# CHANGE REQUEST AND CONSULTATION REPORT NO 2: 9.19

## Cory Decarbonisation Project

**PINS Reference: EN010128**

**January 2025**

WEST ELEVATION
SCALE 1:750

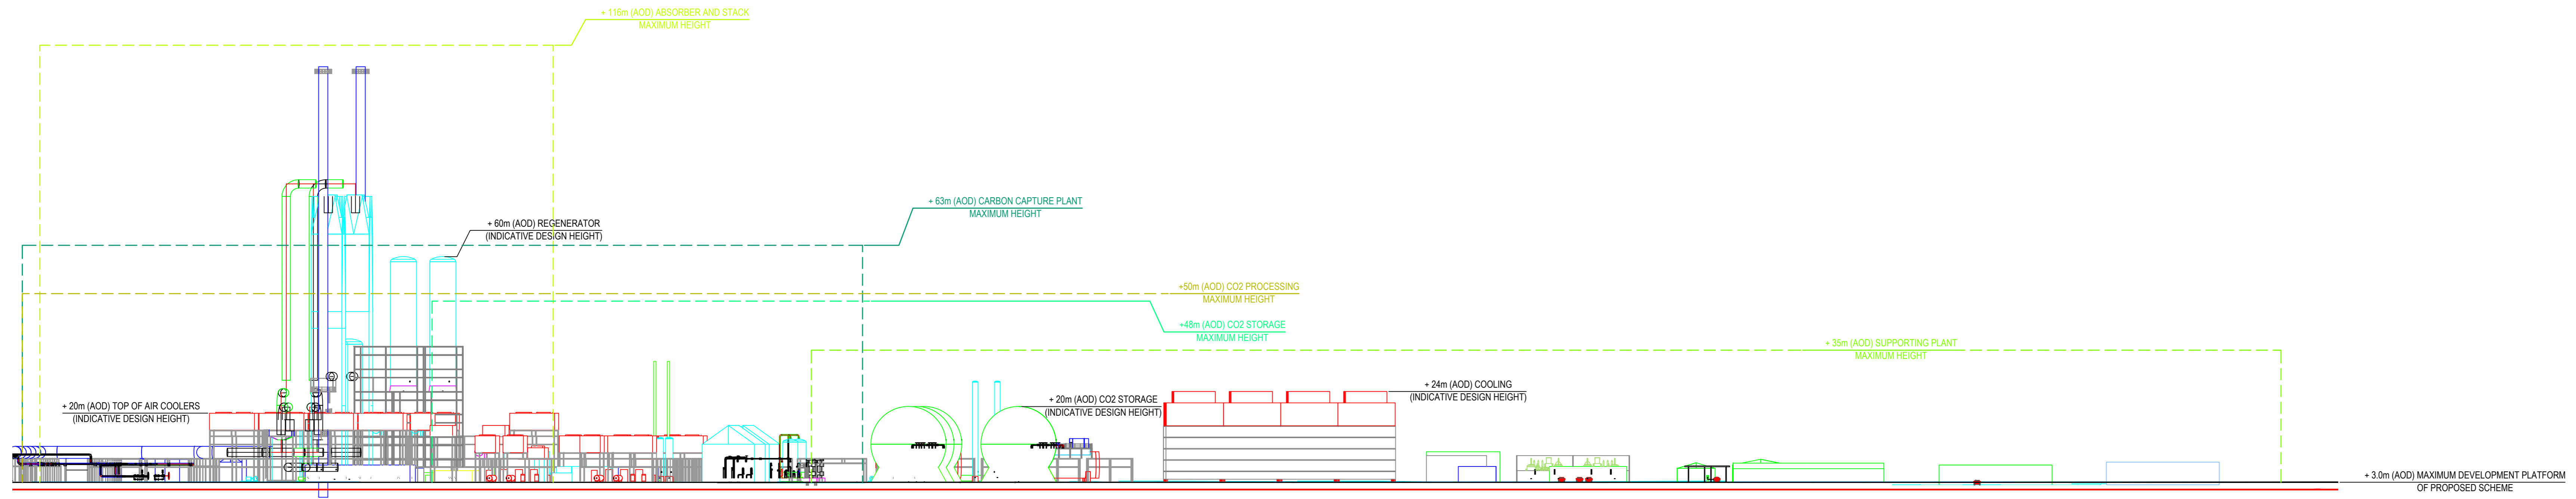
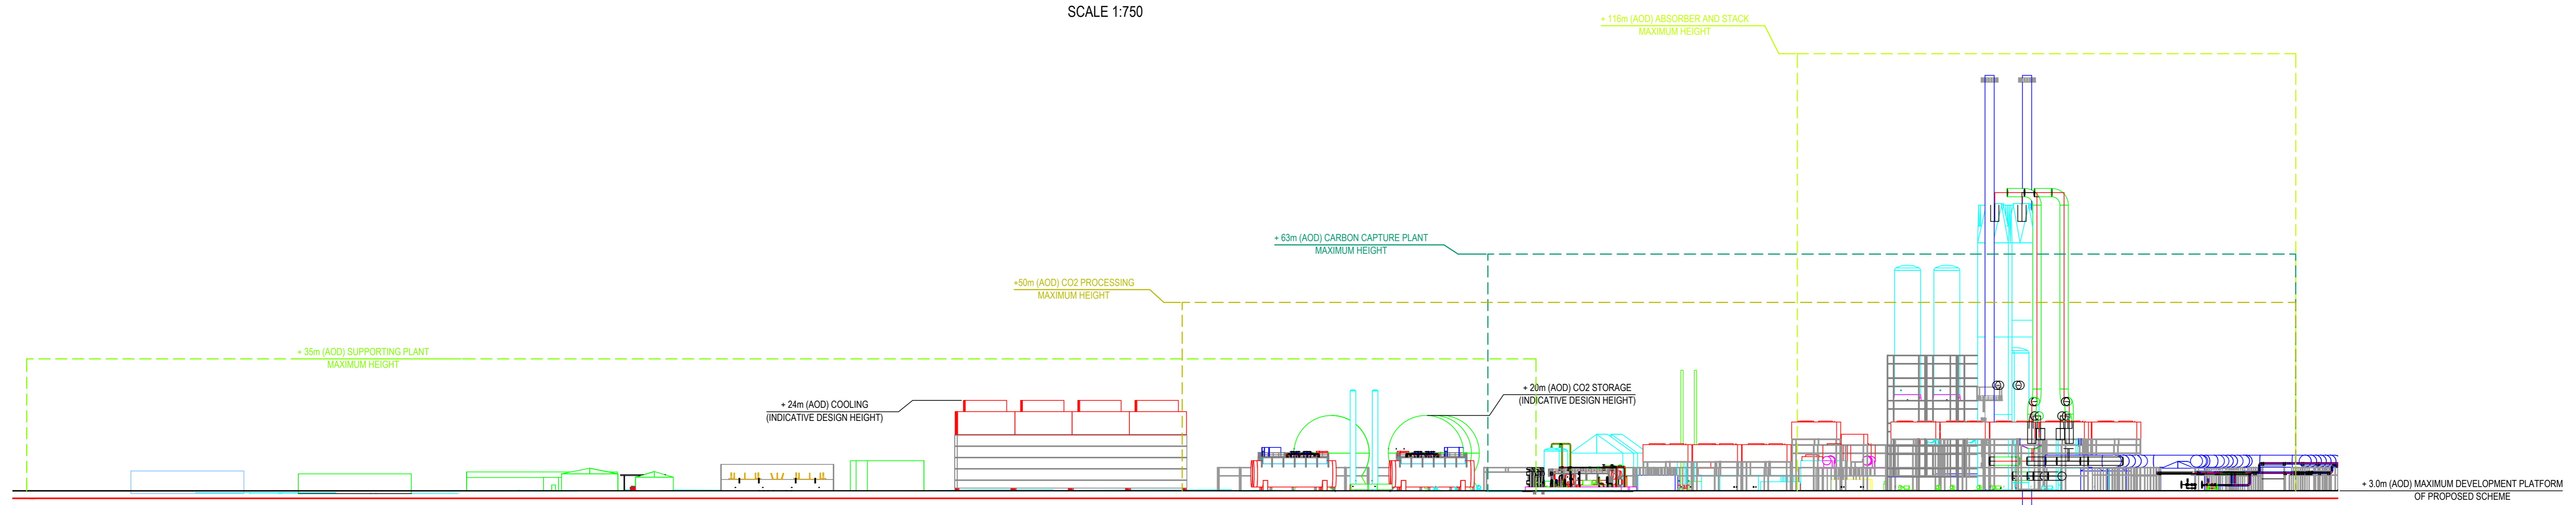
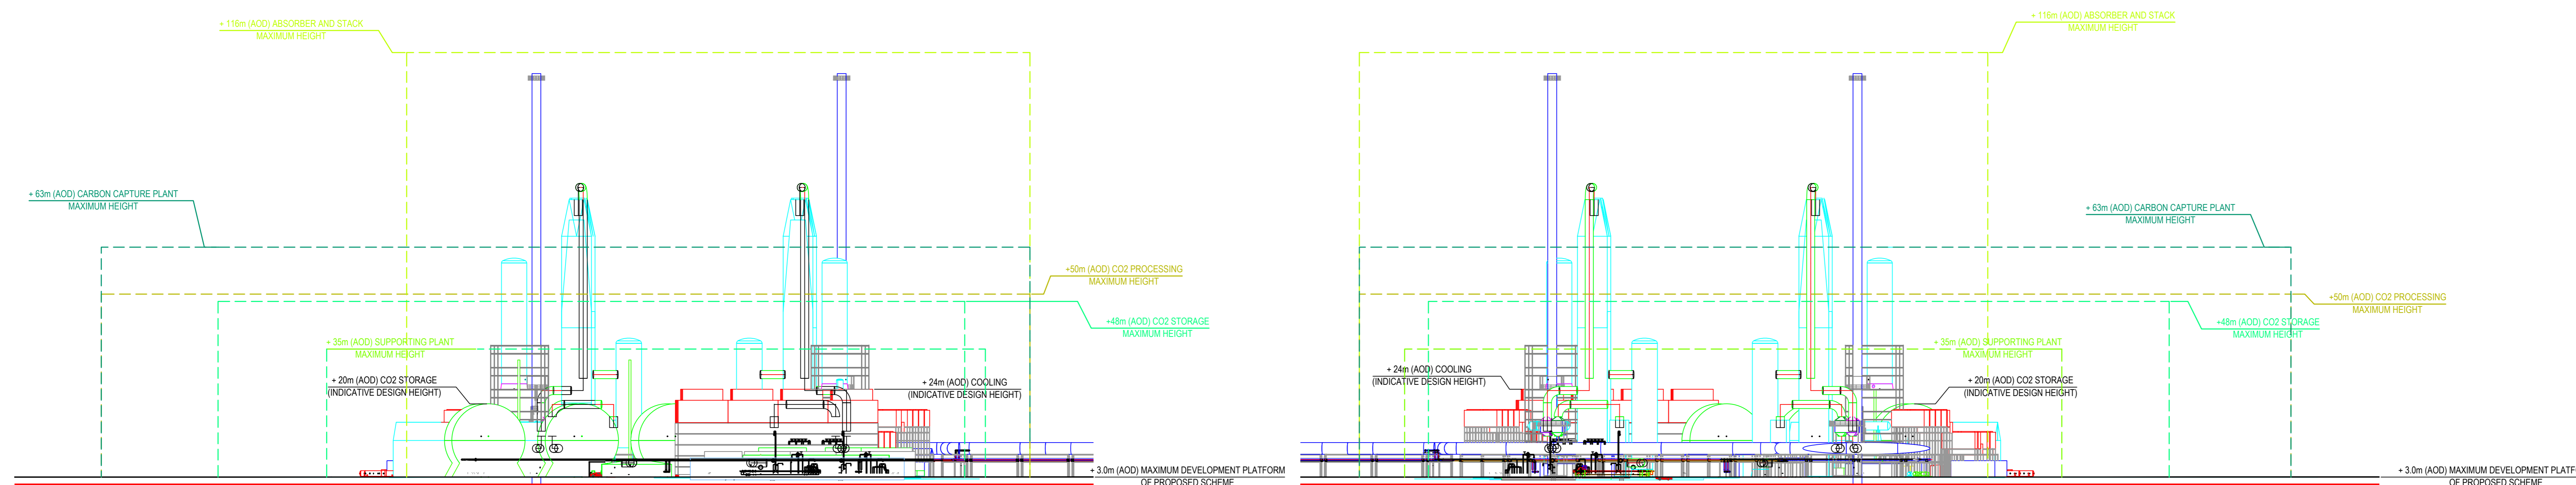
- Work Number 1B – Provision for reconfiguration of the Stack(s) from the top of the Absorber Column(s) to potentially be connected to, but forming a separate stack, or totally separate from, and directly adjacent, to the Absorber Column(s) (**Change 2**); and
- Parameter change – Provision to increase in the maximum height of the ‘Regenerator’ from 50m to 60m (53m AOD to 63m AOD) (**Change 3**).

- 2.2.4. Change 2 is relevant to Work Number 1B and would enable the options for the Stack(s) to be connected to, but forming a separate stack, or totally separate from, and directly adjacent to, the Absorber Column(s). The current design allows only for them to be placed on top of the Absorber Column(s). This change would facilitate a ground-mounted gas-gas heat exchanger, which may enhance heat recovery and reduce the cooling load for the Carbon Capture Facility.

- 2.2.5. The height of the Stack(s) will remain similar to the current proposals. The Change will retain the minimum 30m vertical distance between the top of the Stack(s) and the top of the Absorber Column(s) to avoid downwash of pollutants and will the Stack(s) remain within the work area identified on the **Works Plans (REP2-003)**. There would consequently be no change in the impact of emissions from the Stack(s) on sensitive receptors.

- 2.2.6. This change relates to the parameters set by the Applicant, specifically those set out in **Table 2-2** within **Chapter 2: Site and Proposed Scheme Description** of the **Environmental Statement (APP-051)** and **Schedule 16 of Draft DCO (Document Reference 3.1)**.
- 2.2.7. The Applicant now seeks the flexibility for the Solvent Regeneration System to be able to be constructed, such that the Regenerator Column sits above the Solvent Processing System, rather than separately, thereby increasing the overall height of the System from 50m to 60m (53m AOD to 63m AOD). The parameter would require amendment to authorise this Change.

- 2.2.8. This change would facilitate gravity drainage of the solvent from the bottom of the regenerator column down into the reboiler, which will sit below it. There would also be a greater liquid head (Net Positive Suction Head – NPSH) for the solvent circulation pumps returning the lean solvent back to the absorber, benefitting the operation of these pumps and increasing the flexibility of pump selection.
